From: [Mau, Russell E \(DOH\)](#)
To: [Rachael Stevie \(CD\)](#)
Cc: [Holly Erdman](#); [Smits, Brenda M \(DOH\)](#)
Subject: RE: SP-21-00002 Lonny - Notice of Application
Date: Friday, December 17, 2021 8:39:38 AM
Attachments: [image001.png](#)

RE: SP-21-00002 Lonny

SUBJECT: Lonny Short Plat SP-21-00002

LONNY SHORT PLAT
PART OF SECTIONS 1 & 2, T. 19 N., R. 15 E., W.M.
KITTITAS COUNTY, WASHINGTON

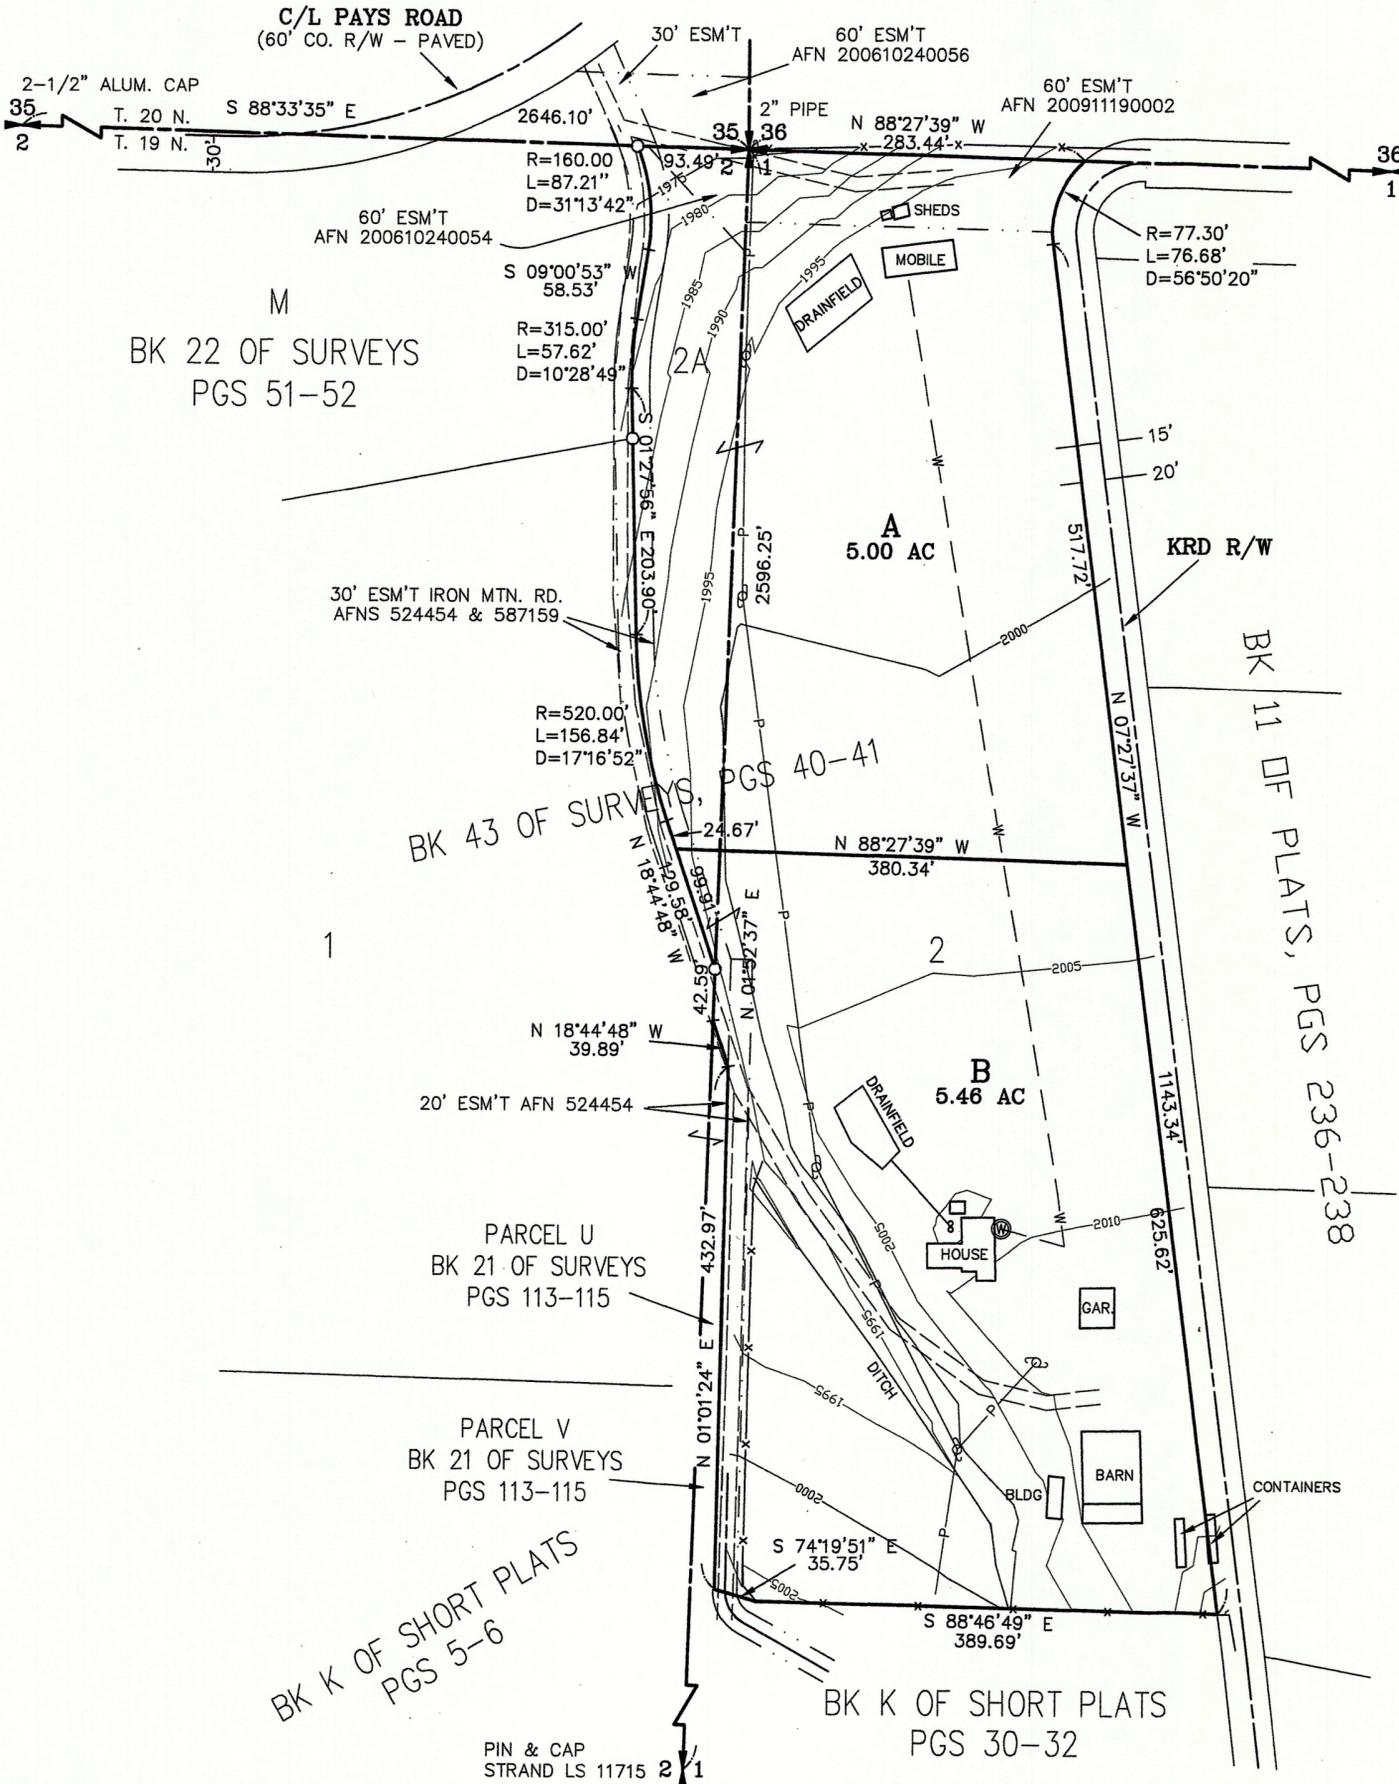
1. This Prelim Short Plat does not meet topo requirements as specified in WAC:332-130-145.
2. Overhead power and underground water lines are not shown within the legend.
3. A number of dimensions are obscured by crossing linework.
4. The position of easement 524454 in Parcel B, does not match survey 546065. This discrepancy should be noted.
5. Basis of bearing is not noted.
6. The Northernmost line of West boundary of Lot B does not match lot closures. (99.91 vs 104.91)
